Application No: LU/13/21/PL
Site Address: 125 Bayford Road Littlehampton BN17 5HW
Description of works: Change of use of existing single dwellinghouse (C3) to an 8-bedroom House in Multiple Occupation (Sui Generis).

Thank you for your internet representation made on 3rd February 2021 which has been recorded as an objection with the comments as follows:

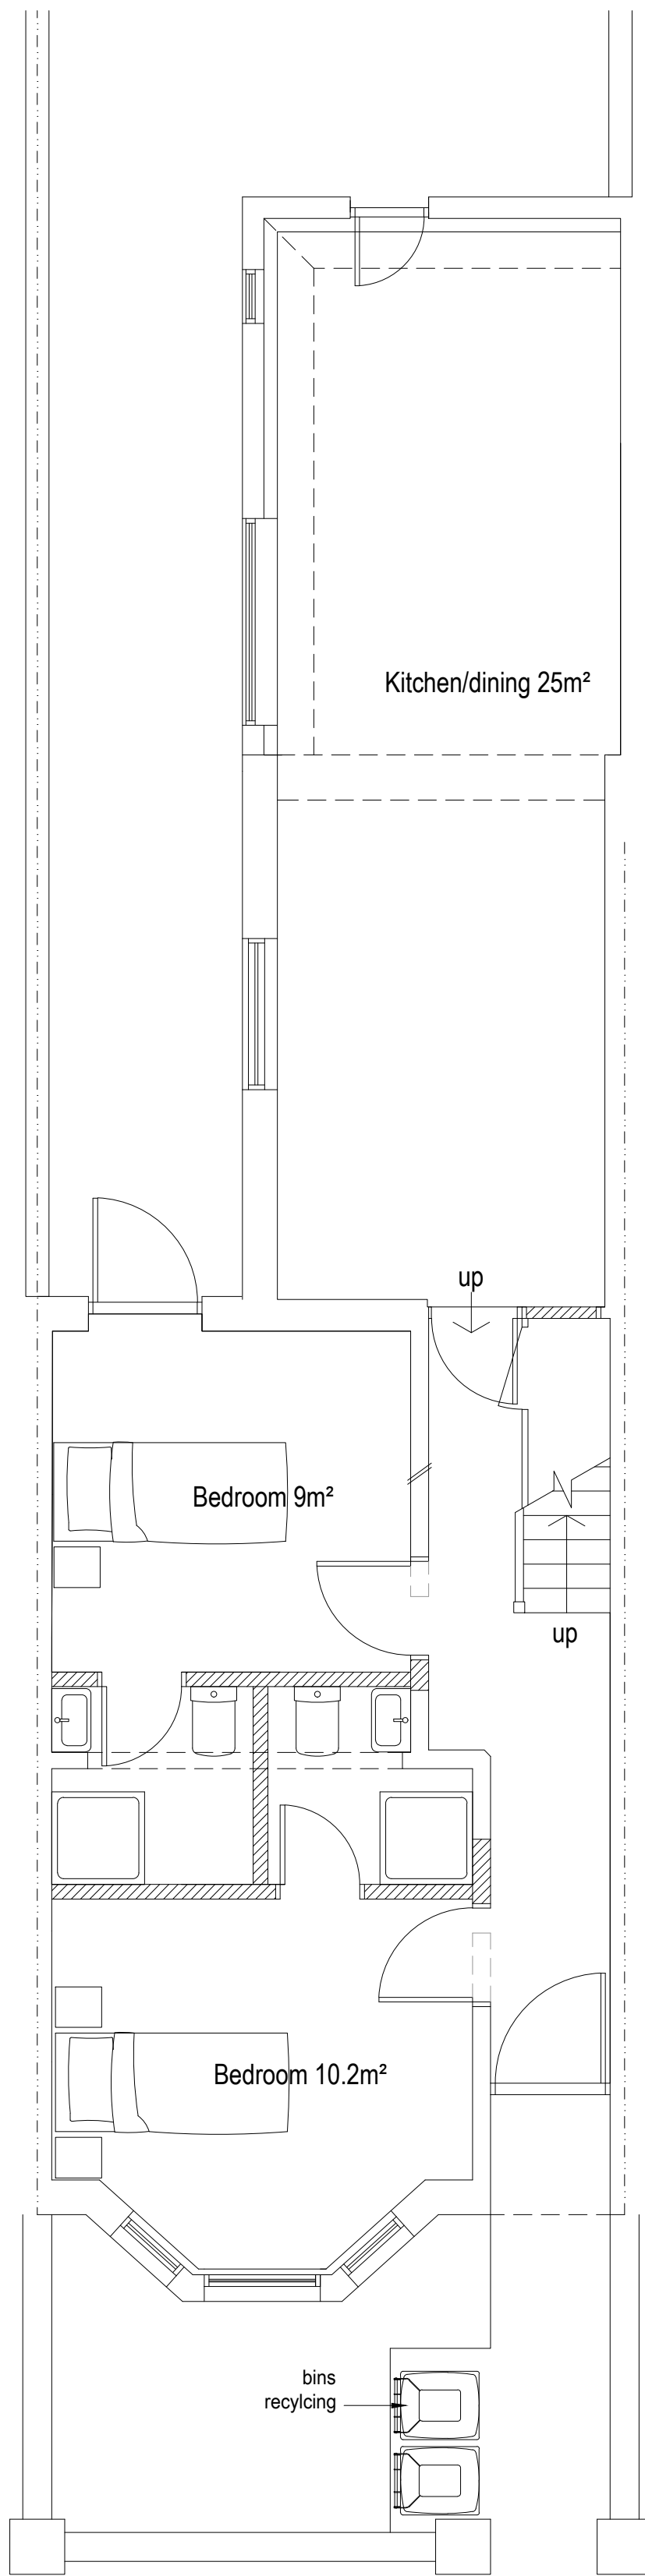
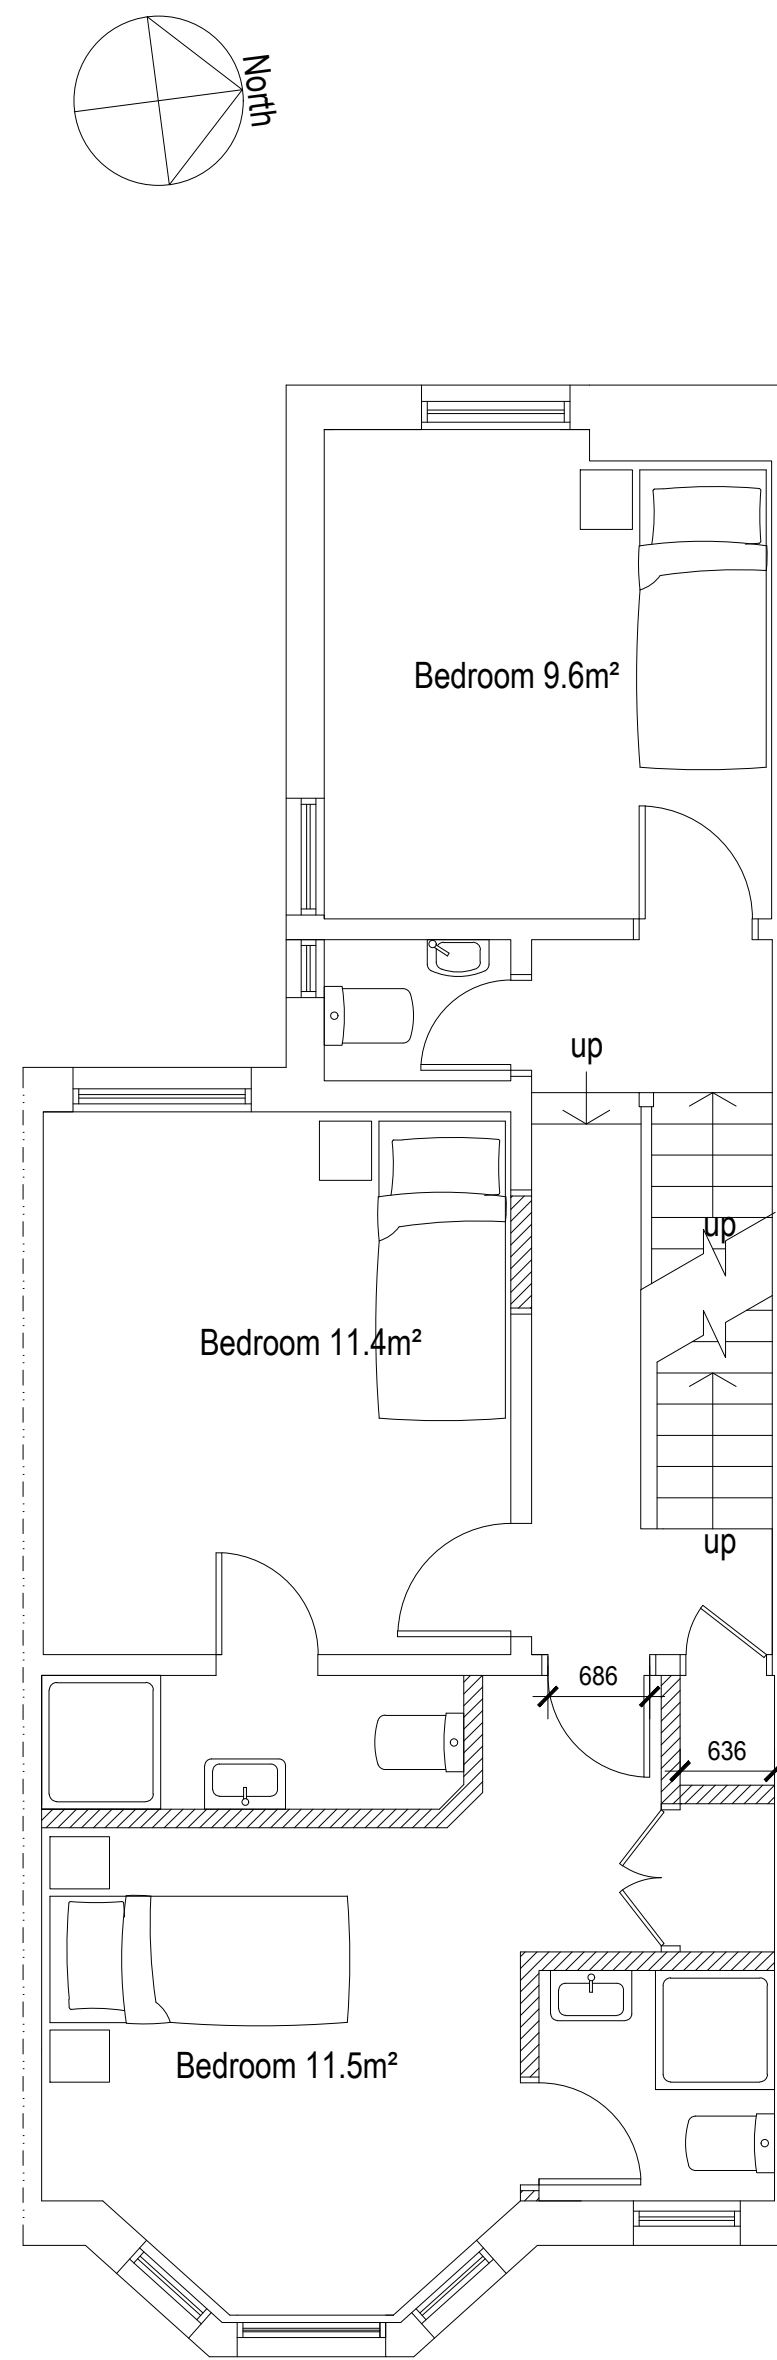
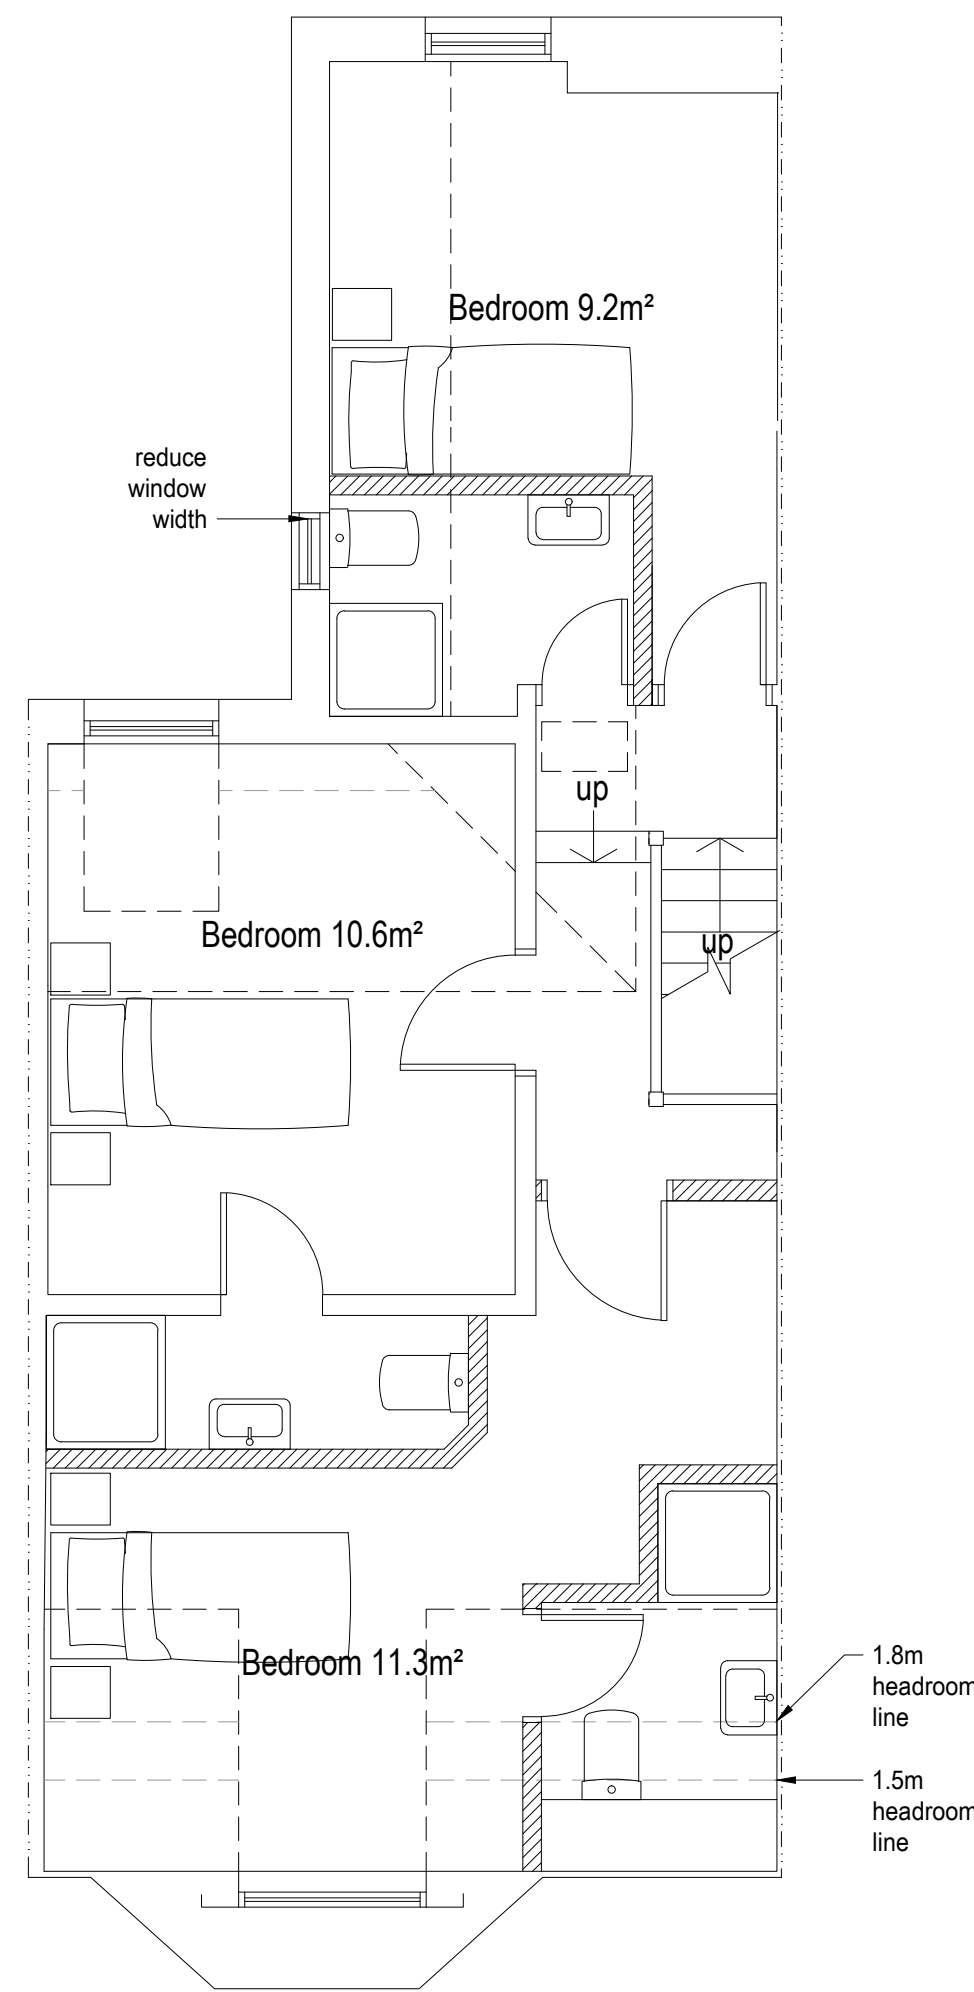
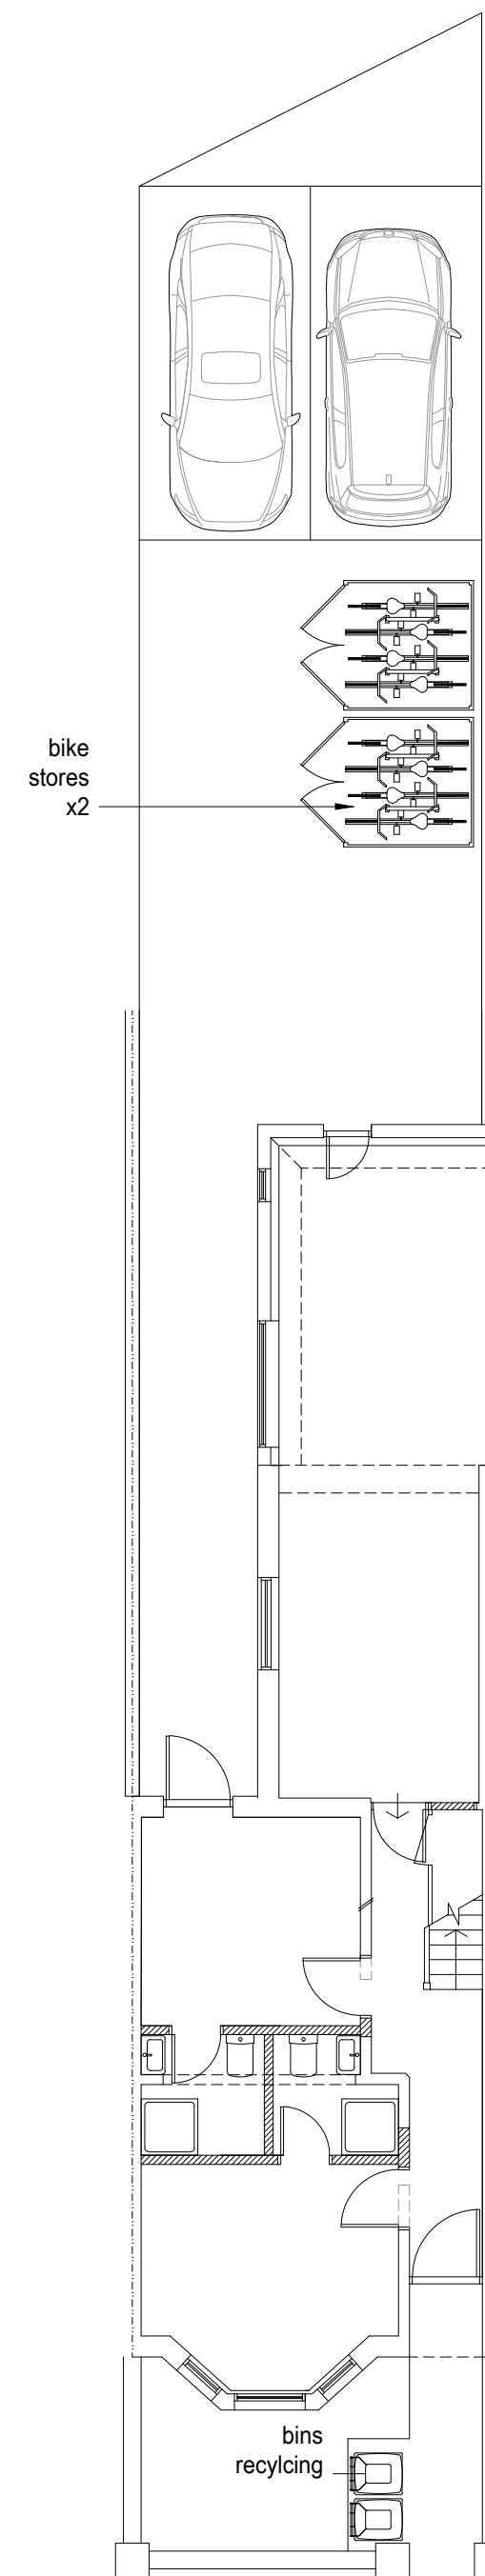
The Town Council's Planning and Transportation Committee considered this matter at its meeting held on Monday 1st February and object to the application on the grounds that it does not comply with Policy H SP4, Houses in multiple occupation, of the Arun Local Plan. This policy states that: "Where planning applications for houses in multiple occupation (HMOs) are not already covered by permitted development rights, they will be favourably considered where the proposals contribute to the creation of sustainable, inclusive and mixed communities and meet the following criteria: a. Do not adversely affect the character of the area including eroding the balance between different types of housing, including family housing, b. Do not contribute to the generation of excessive parking demands or traffic in an area; c. Provide adequate areas of open space." The Committee considered that the proliferation of HMO's in this area is destroying the character of the area, reducing the number of dwellings available for much needed family homes and bring more pressure to bear local infrastructure, particularly medical facilities. Observing the number of objections to this application Members were also concerned about the impact of this development on the residential amenity of other residents in the area which was contrary to Policy DDM1 of the Arun Local Plan. In addition, it was observed that the plans proposed shared bathroom facilities which was not considered acceptable.
